Application no: **3/2020/0187**

Address: **Rockhaven Ribchester Road Clayton le Dale BB1 9EG**

Proposal: **Alterations to a detached bungalow including two extensions to the front, an altered roof pitch and a detached garage with new front boundary gates and a new stone wall**

Title
**Proposed site layout plan and Garage
 Entrance details**

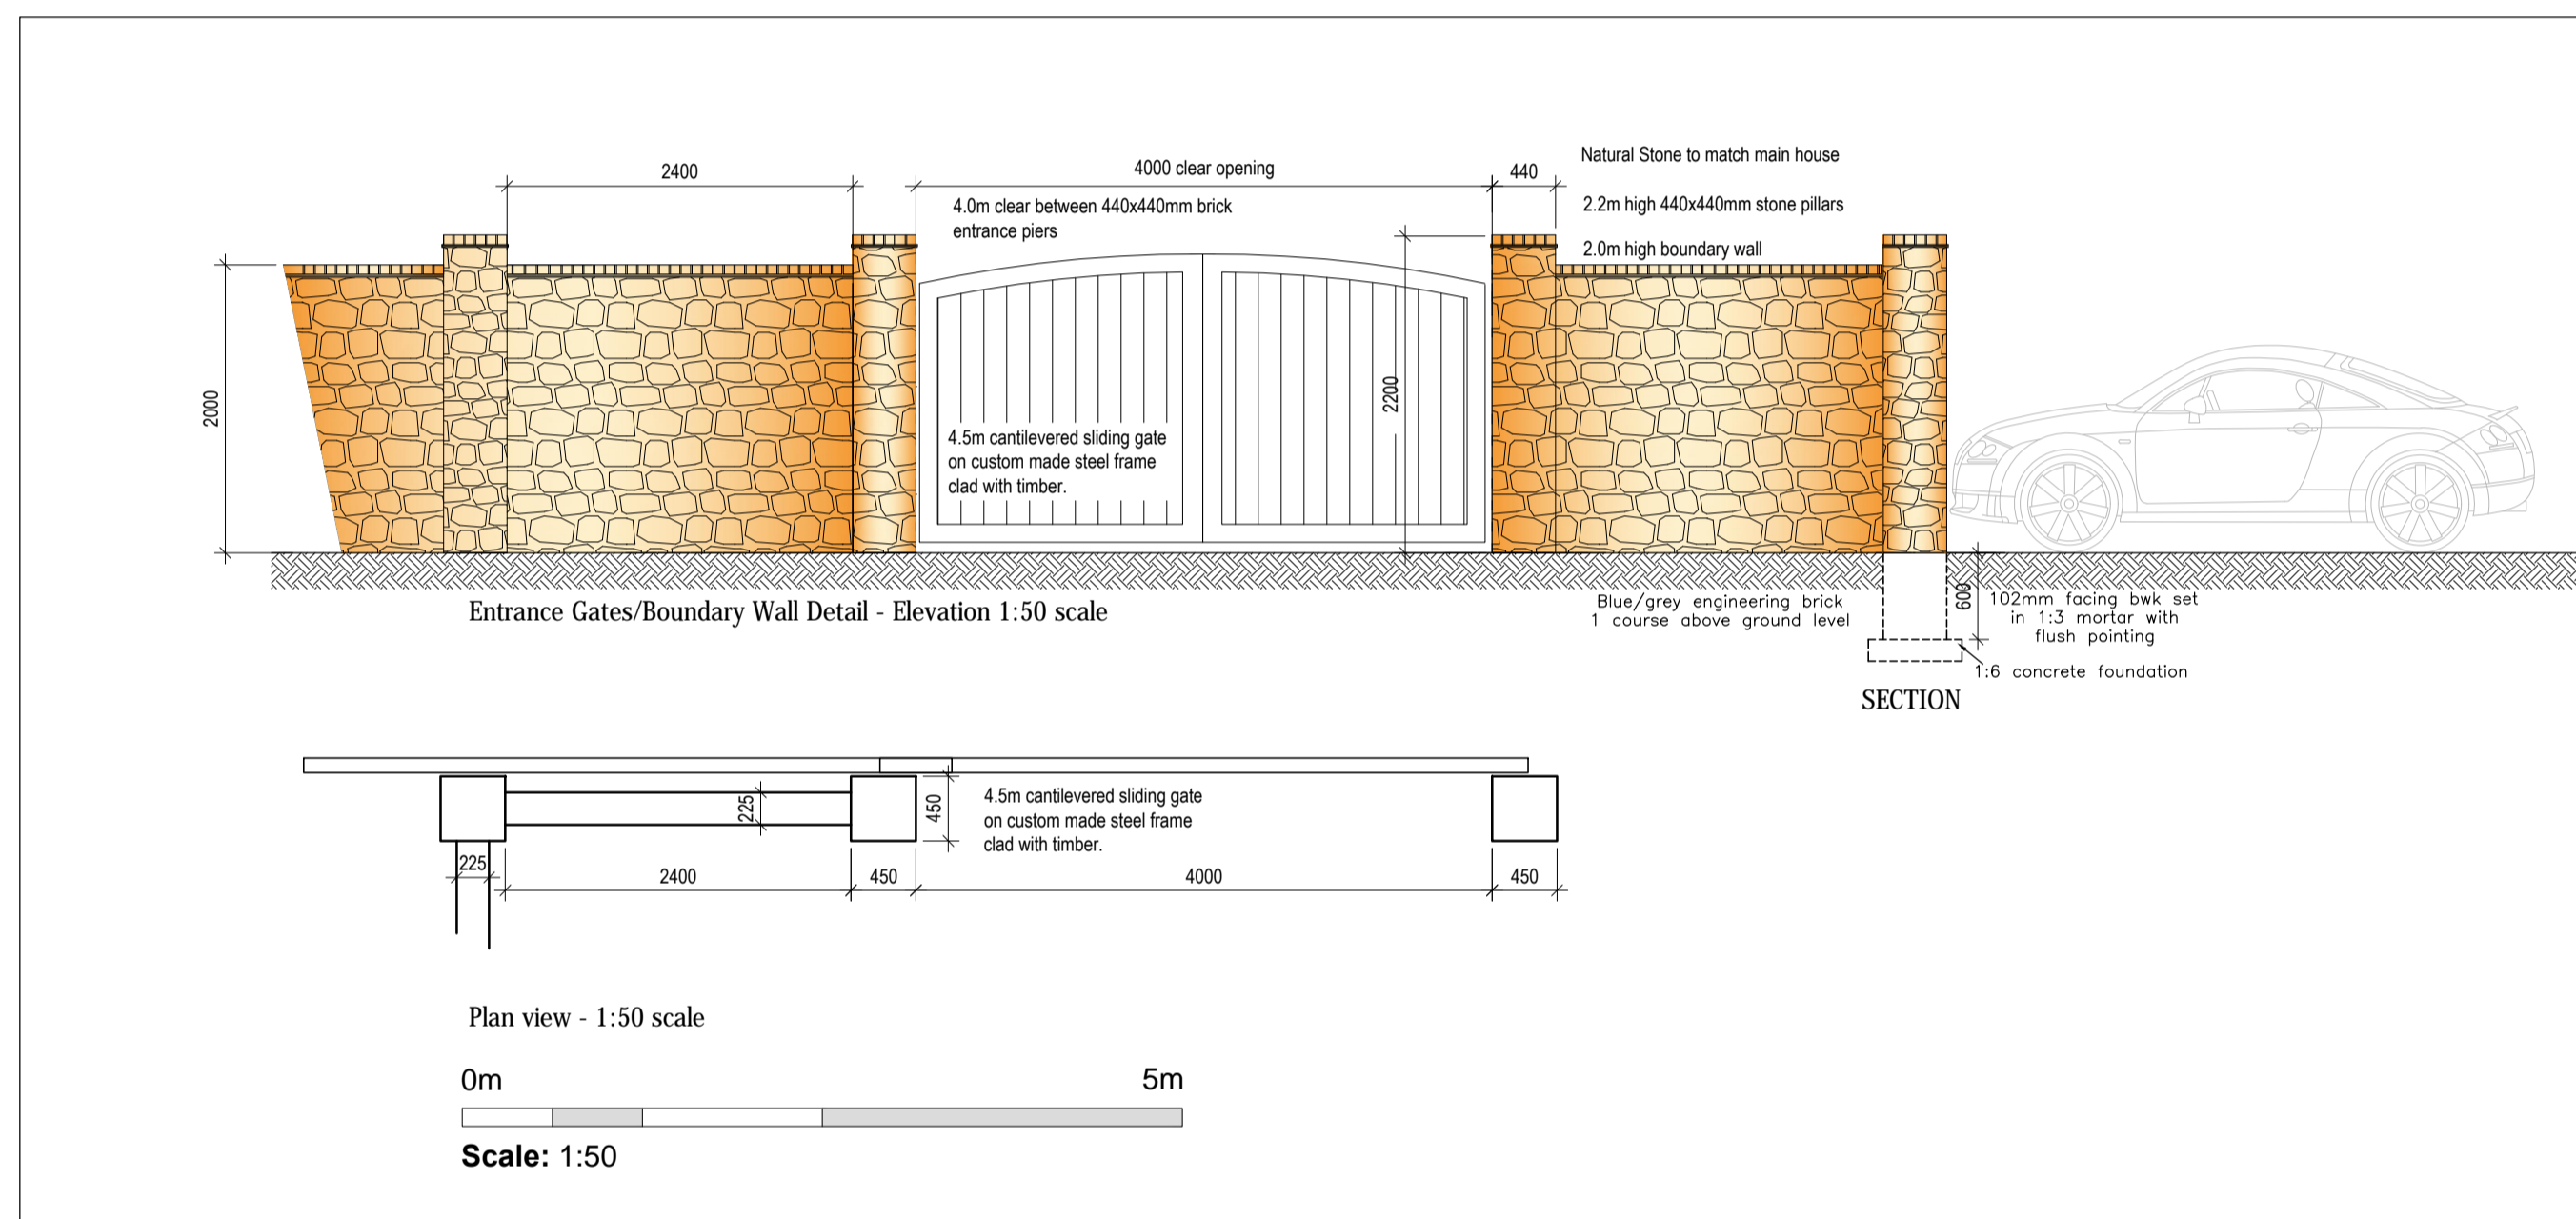
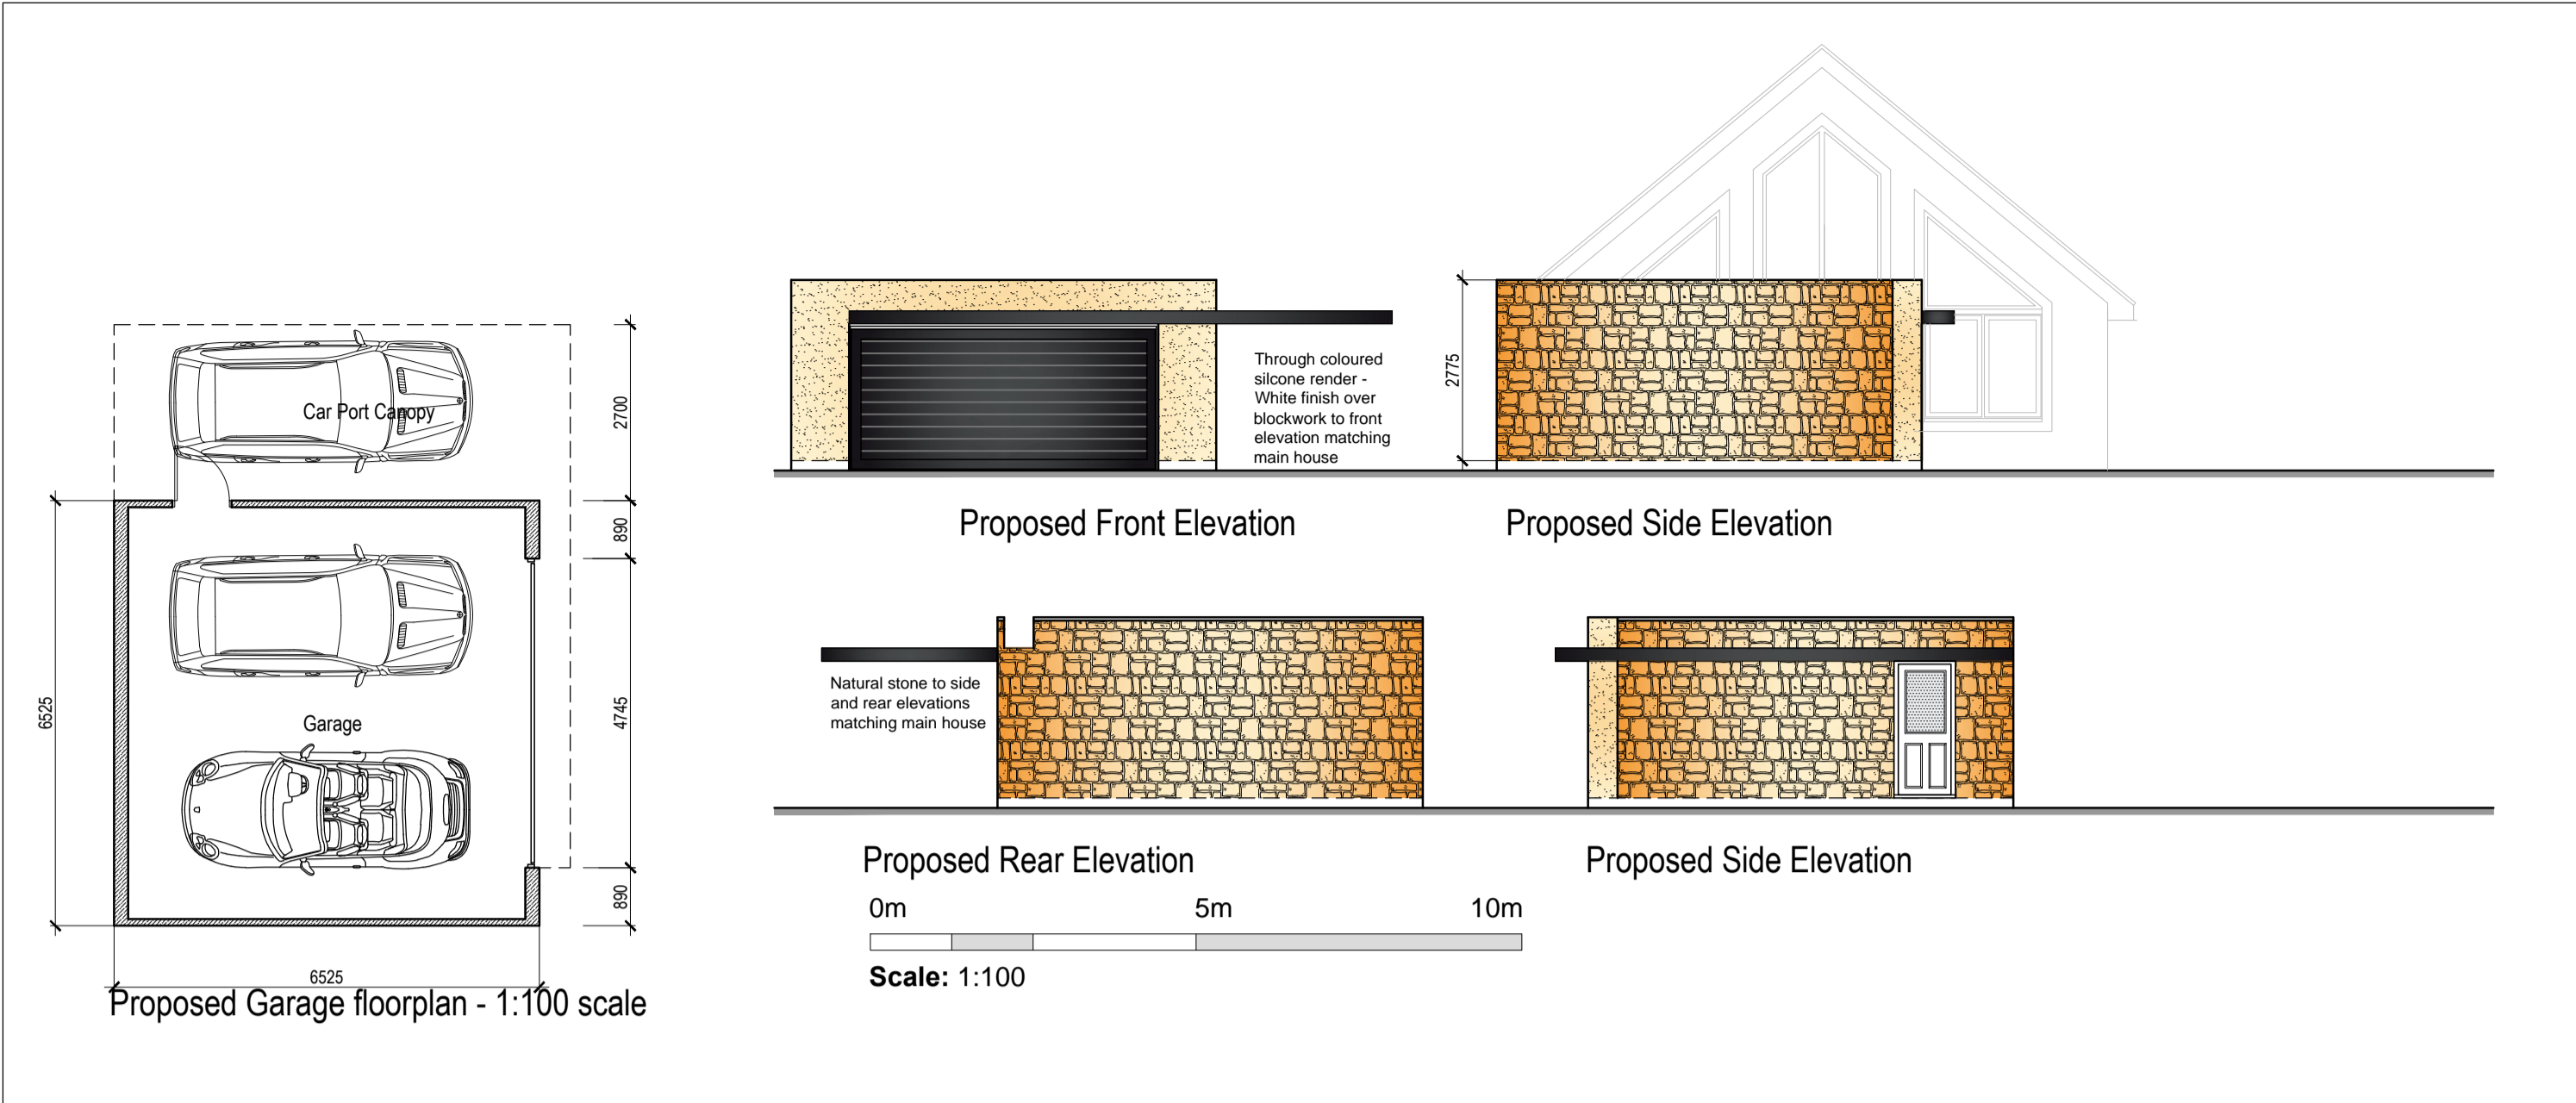
Whilst I would raise no objection to the principle of the proposed development, I would need to be satisfied that the proposed access arrangements are suitable for the proposal and whilst looking at the submitted proposed site plan, the annotations are not clear enough to interpret, therefore I ask that a detailed access arrangement drawing is submitted, detailing the proposed access arrangements including dimensions, thus providing clarity as to what is being proposed at the existing access point.
